CITY OF ALBUQUERQUE

**RE: Lot 4 Block 5 Unit 18 Volcano Cliffs SAD 228
6611 Papagayo NW
Grading and Drainage Plan
Engineers Stamp Date 8/6/18 (D10D003K4)**

Based upon the information provided in your submittal received 8/16/18, this plan cannot be approved for Grading Permit until the following comments are addressed.

ENGINEER'S SEAL  9/19/18 DAVID SOULE P.E. #14522	6611 PAPAGAYO RD NW HINCHMAN RESIDENCE GRADING AND DRAINAGE PLAN  Rio Grande Engineering 1608 CENTRAL AVENUE SE SUITE 201 ALBUQUERQUE, NM 87106 (505) 972-0899	DRAWN BY DEM
		DATE 9-18-18 HICHMAN G&D PLAN 9-18-18.DWG SHEET # C1 JOB #

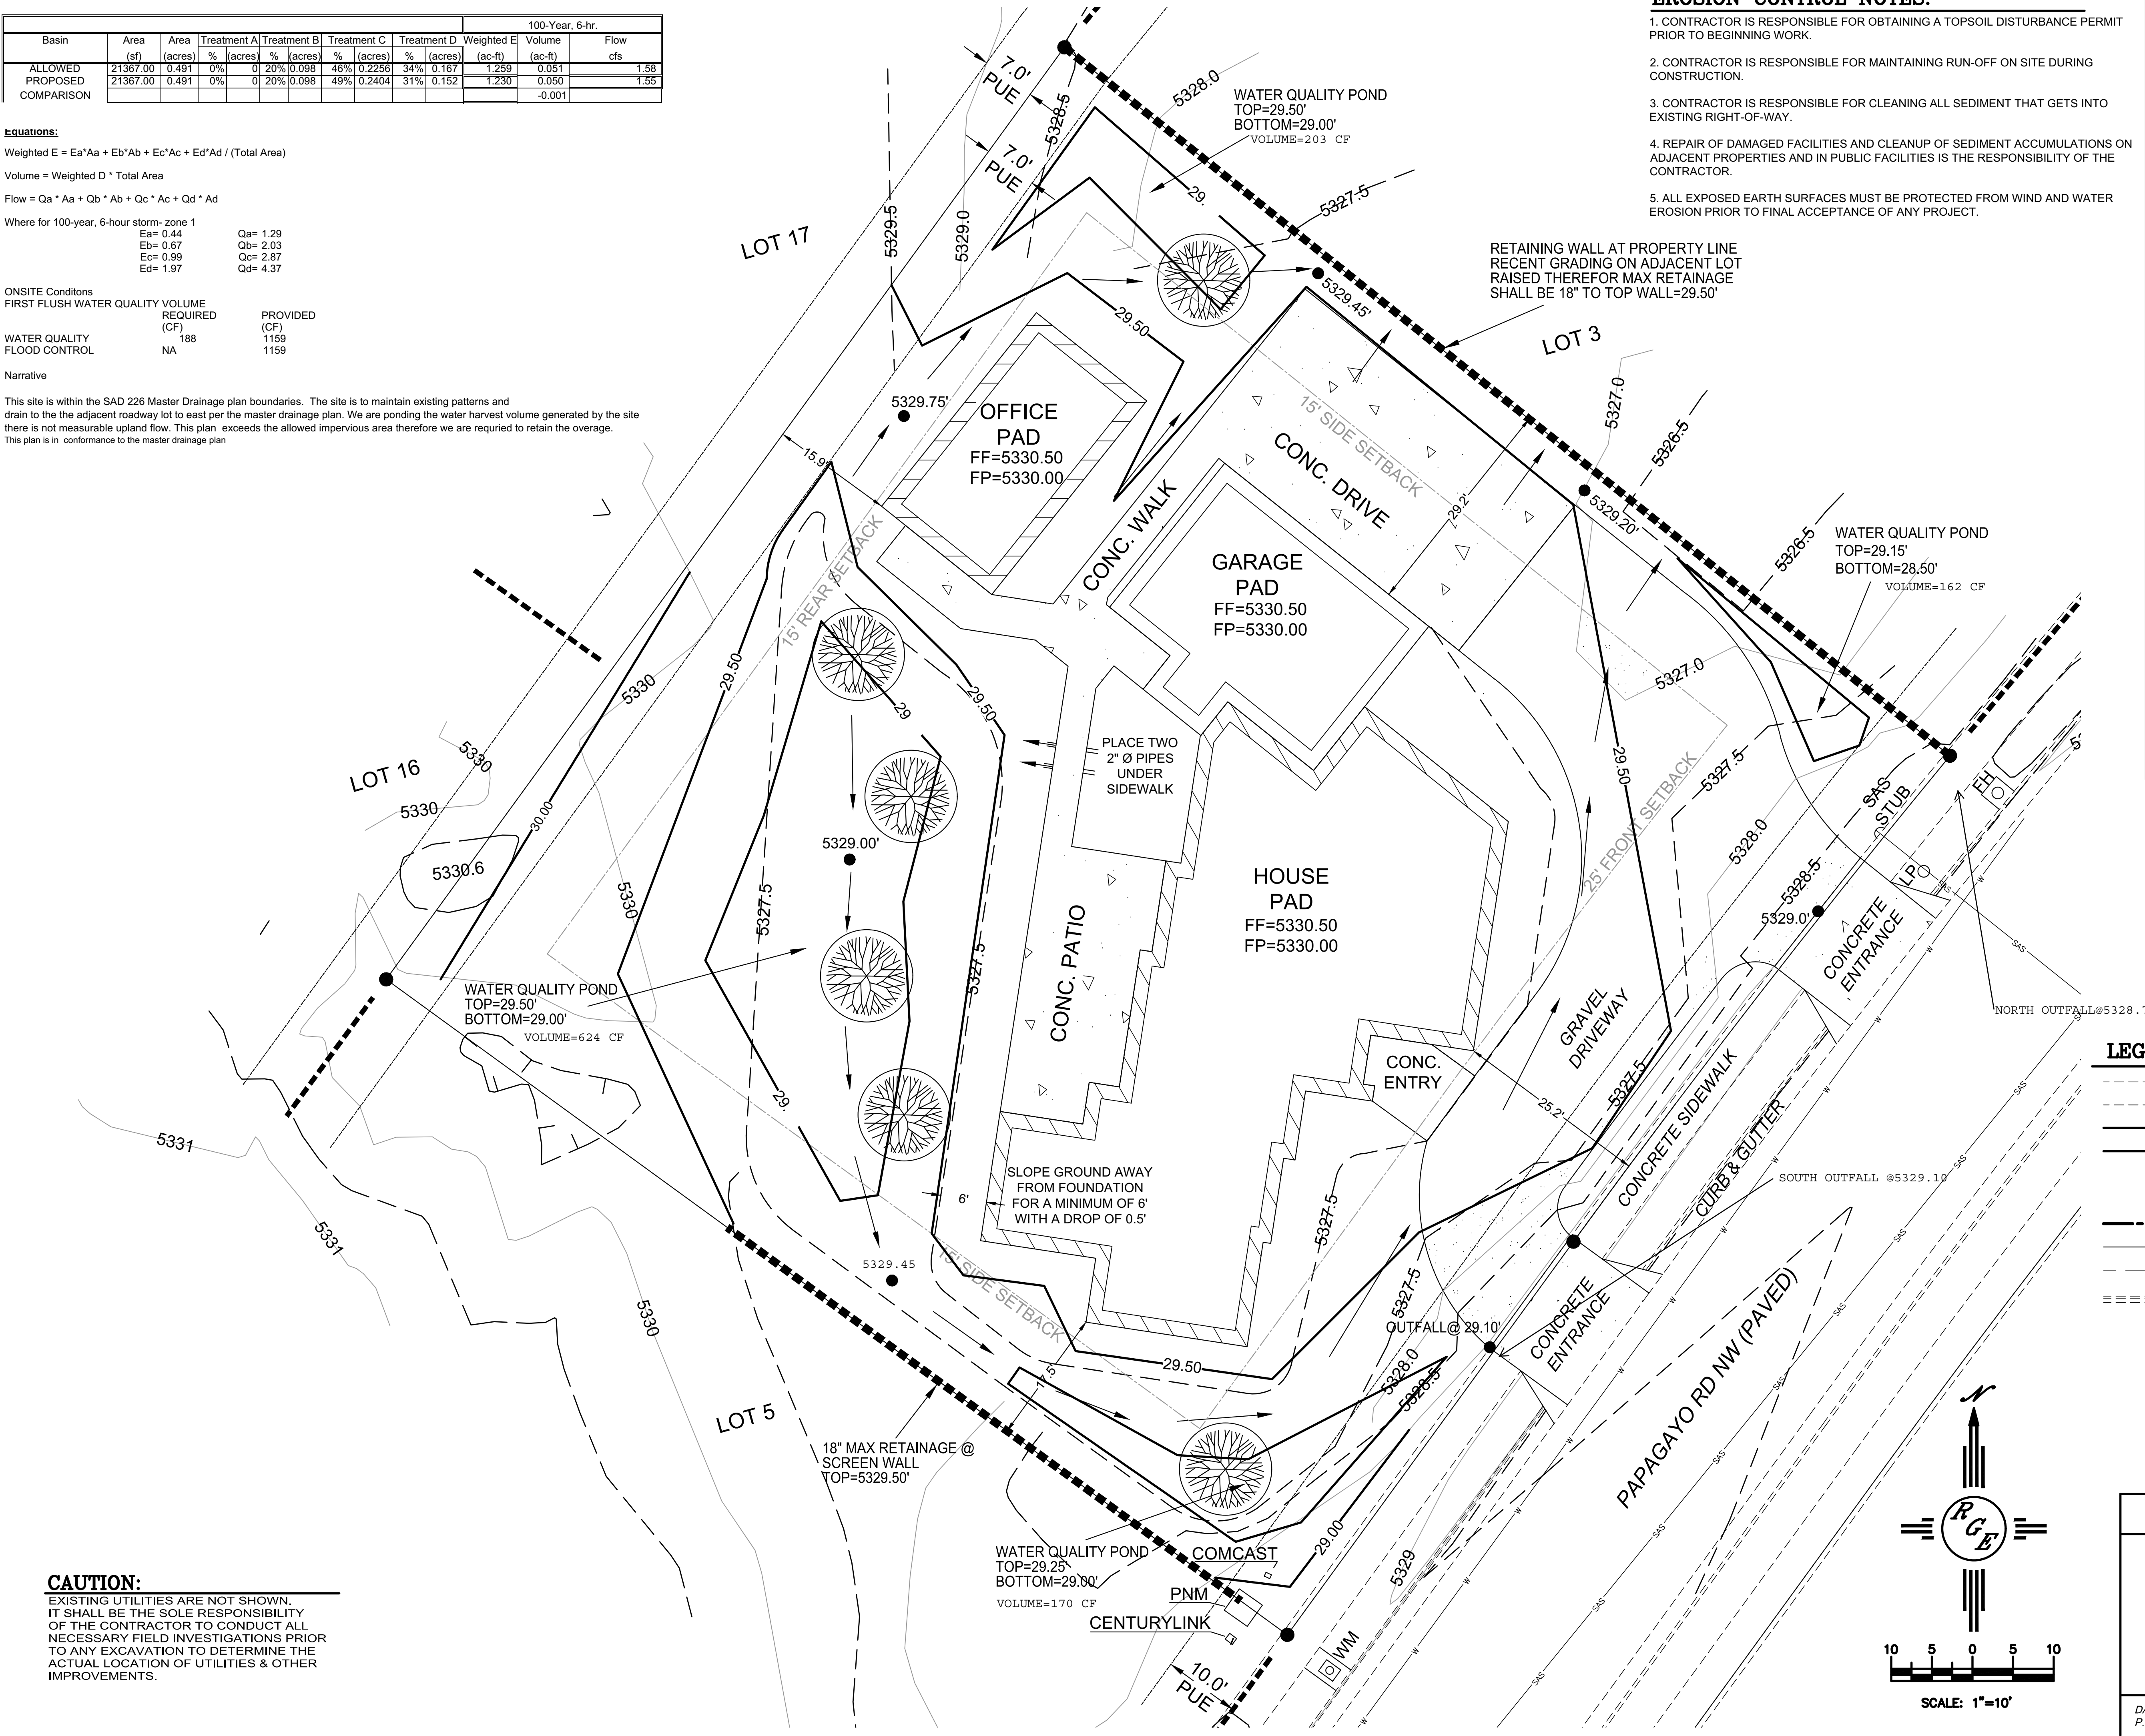
- All flows must drain to the street or pond on the lot. This lot should not drain onto the adjacent lot.
- Raise FP above top of curb at least 1 ft.
- Provide a statement that all garden walls are to be permitted separately.
